Planning Officer: Zac Denton

Planning Application Ref: FP/153/17/T

Location: Piorry Garty 16 Roundle Square, Bognor Regis

Description of works: 3m crown reduction to 1 No Copper Beech

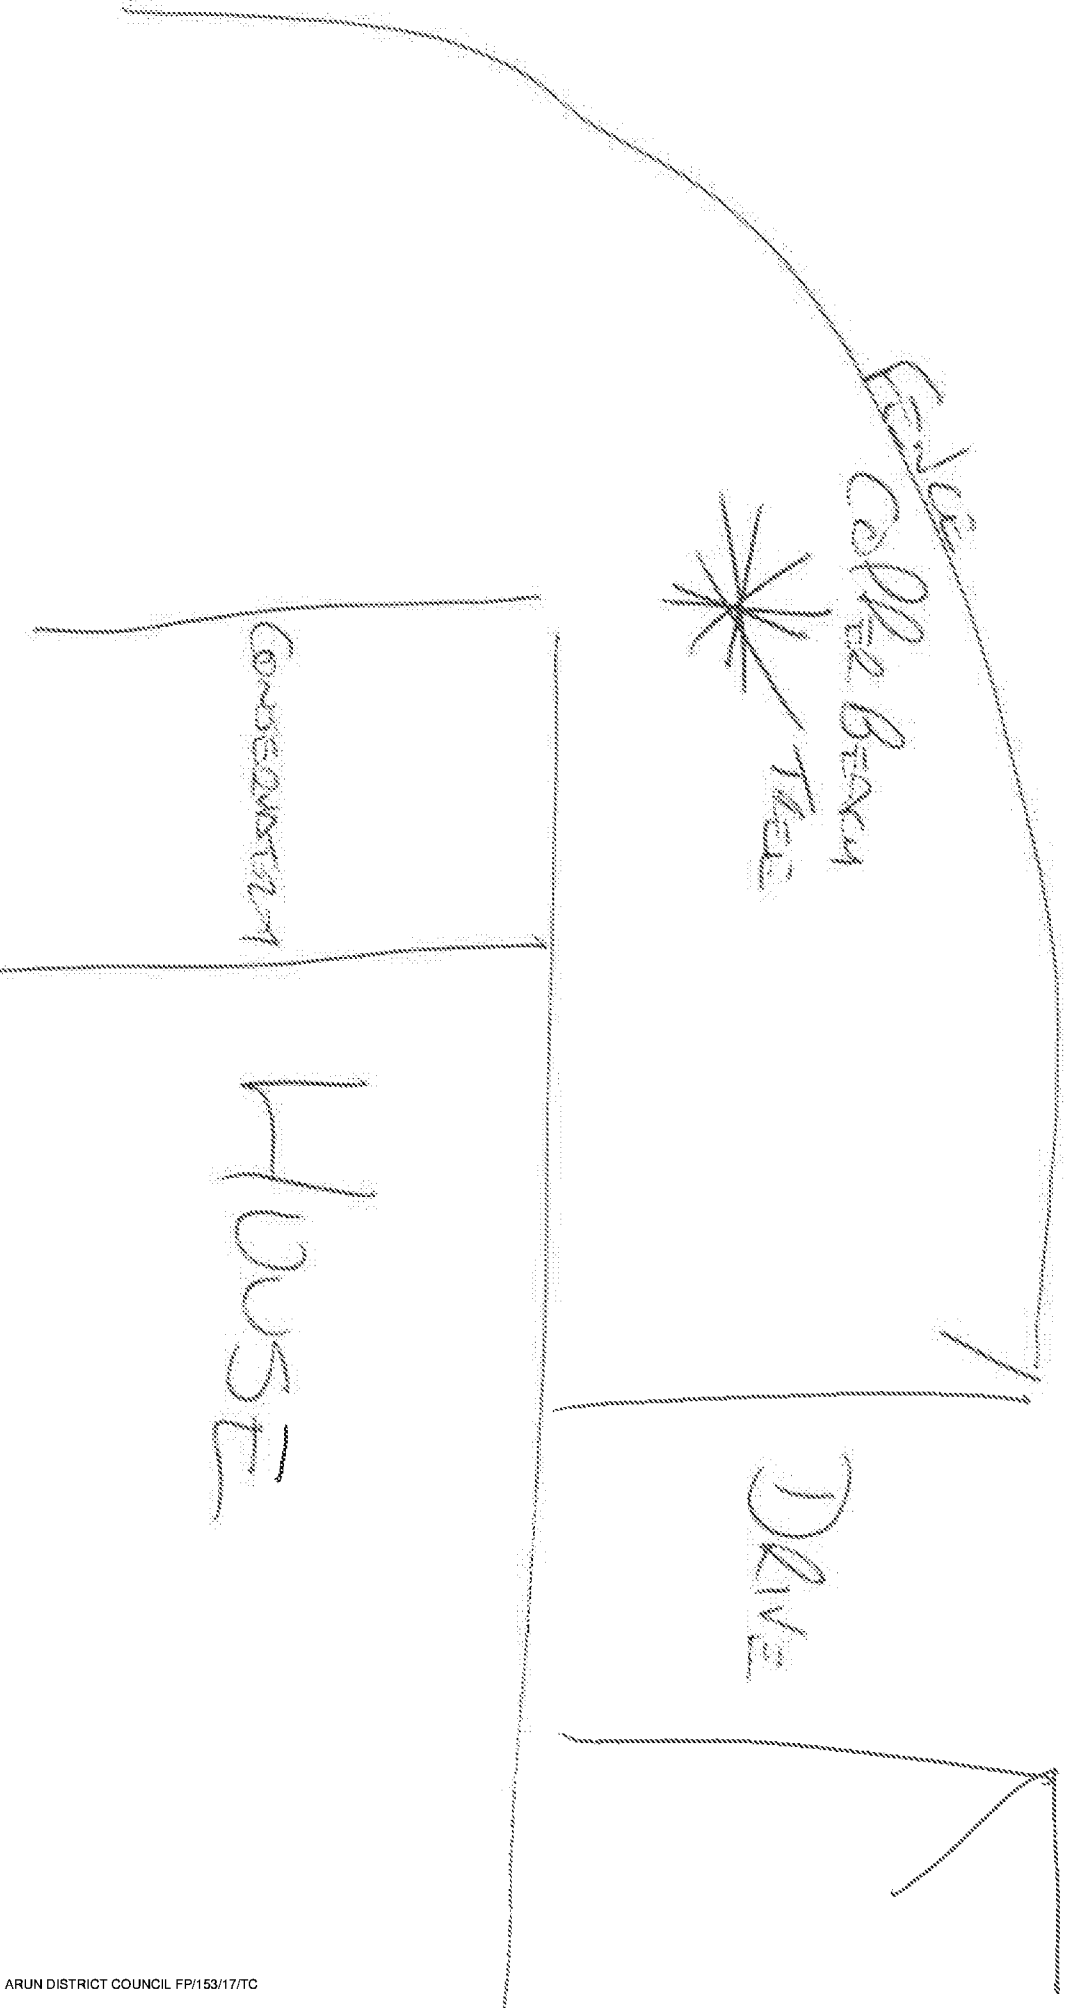
- A mature tree of low spreading proportions due to previous pruning regime.
- Due to its dense canopy and low branching habit and dark purple leaf It causes shading of the front garden being positioned to the south side of same.
- I would support some pruning work to keep this tree under control.

- The proposal to reduce the height and spread by 3m exceeds the recommendations of BS3998 and would be likely to result in harm to the health and vitality of the tree with large pruning wounds being formed as well as undermining its visual amenity value and impact in the landscape.

- I recommend **REFUSAL** of this application.

1. *Reduce the overall height of the tree by 2.5m to 3m.*
2. *Reduce the length of the lateral branches of the tree in an even and balanced fashion by up to 1.5m maximum.*
